# Appeal Decision

**Appeal Ref: APP/R5510/D/22/3313703**

**56 Beech Avenue, Ruislip, Hillingdon HA4 8UQ**

- The appeal is made under section 78 of the Town and Country Planning Act 1990 against a refusal to grant planning permission.
- The appeal is made by Mr Anupam Prakash against the decision of the Council of the London Borough of Hillingdon.
- The application Ref 77438/APP/2022/2344 dated 21 July 2022, was refused by notice dated 7 October 2022.
- The development proposed is described as Single Storey Rear and Part Side Extension, Raising of Garage Roof and Conversion of Garage into a Habitable Space.

Construct 360 Ltd, Trading as: DontMoveExtend .com info@DontMoveExtend.com Tel: 0208 206 0011		Planning Permission Specialists	
56 Beech Avenue Ruislip HA4 8UQ		Proposed Elevations	
Planning Issue		Drawing Number BA56-01-1004

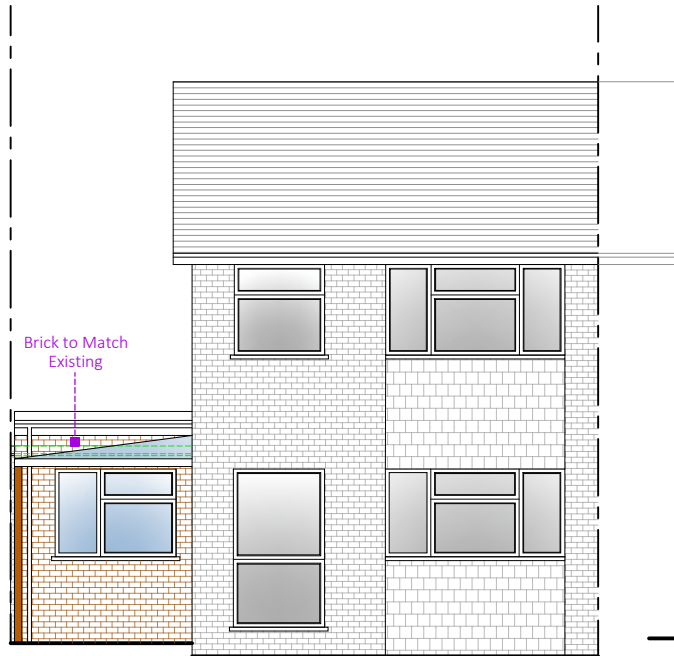
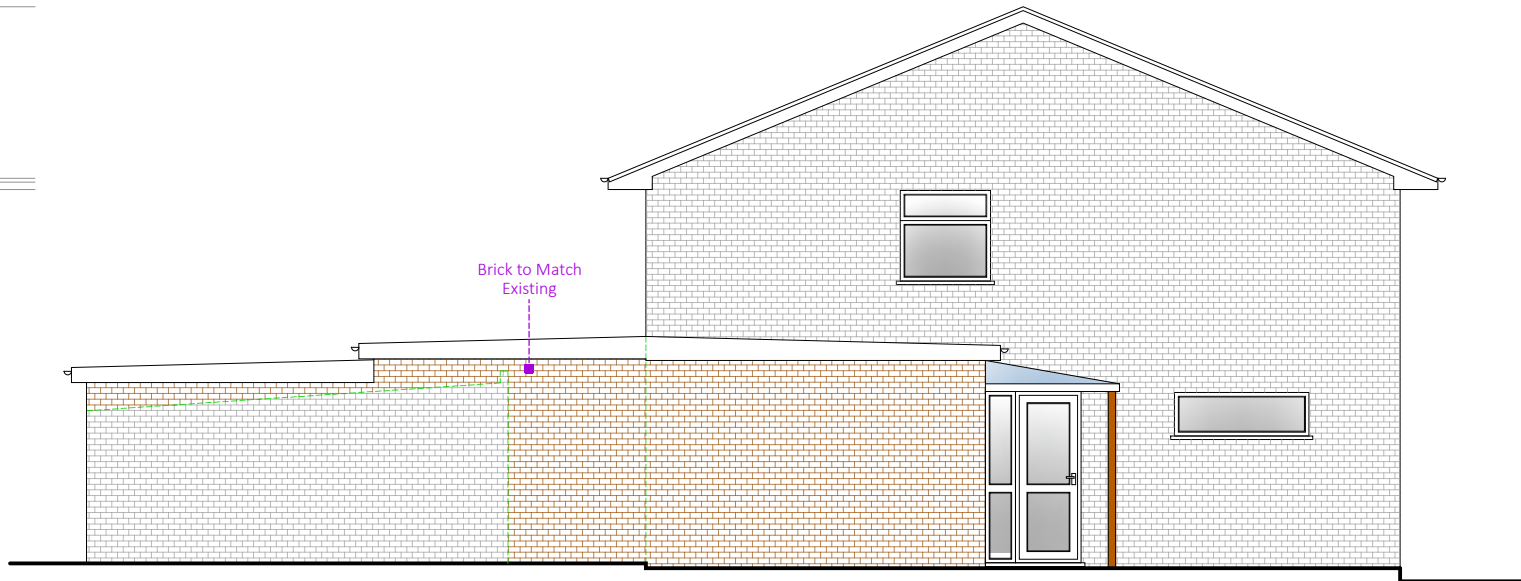
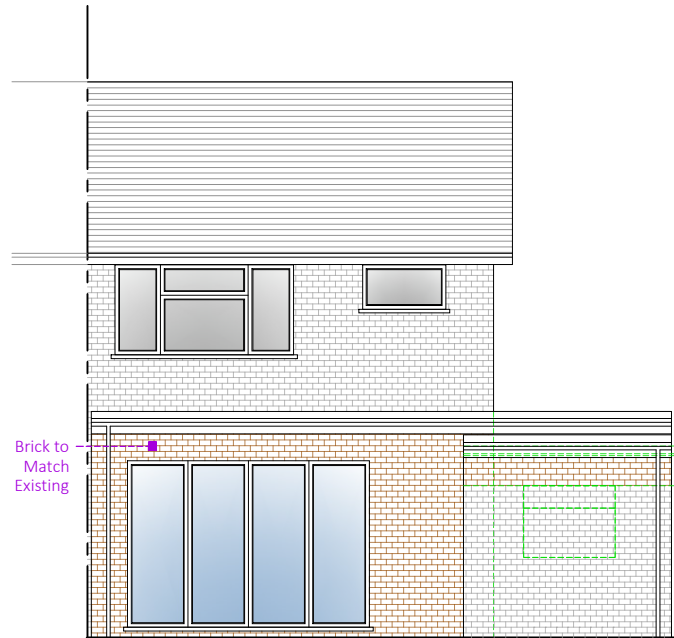
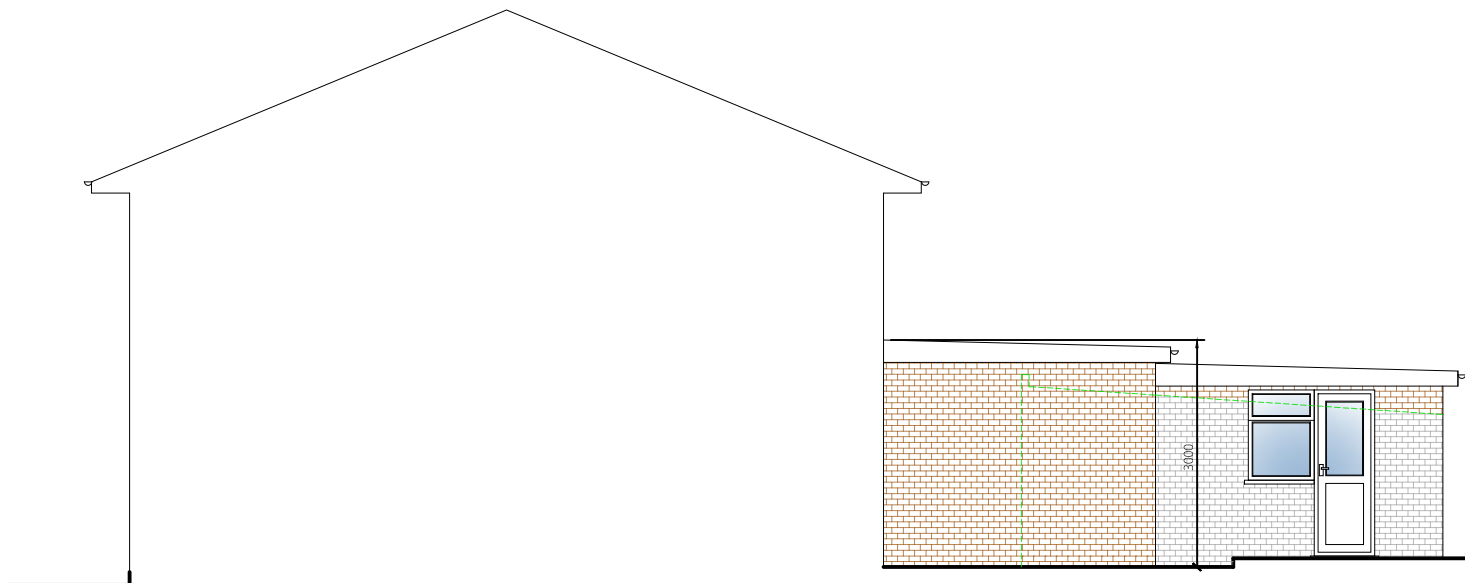
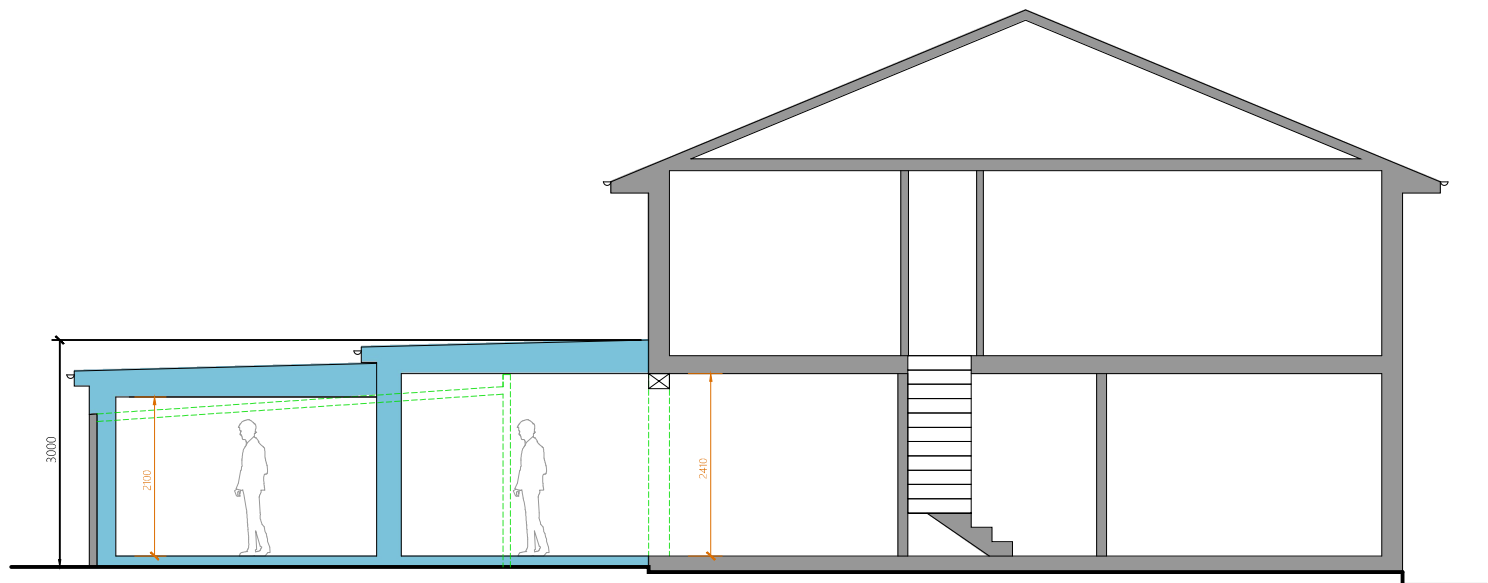
4. The proposed single storey development would wrap around the side and rear of the existing property linking to the existing garage. Whilst there would be an increase in height of the garage, overall development would be relatively low in height.

5. In combination the proposed development would have a large footprint. The existing garage at No. 58 Beech Avenue would screen to a degree the bulk of the proposed development. There would also be limited views of the mass of the proposed development from public vantage points. Notwithstanding this the proposed development would be visible to neighbouring properties, however due to the existing garage and the relatively unobtrusive design I find that the proposed development would not appear disproportionate or incongruous to the existing property or area in general.

6. I conclude that the proposed development would not harm the character and appearance of the existing property and area in general. There is no conflict with Policy BE1 of the Hillingdon's A Vision for 2026, Local Plan: Part 1, Strategic Policies (2012) and Policies DMHB 11 and DMHD 1 the Local Plan Part 2 Development Management Policies (2020), Policy D3 the London Plan (2021) which amongst other things seek to ensure developments are of high quality design which respect the design of the original property and surrounding area.
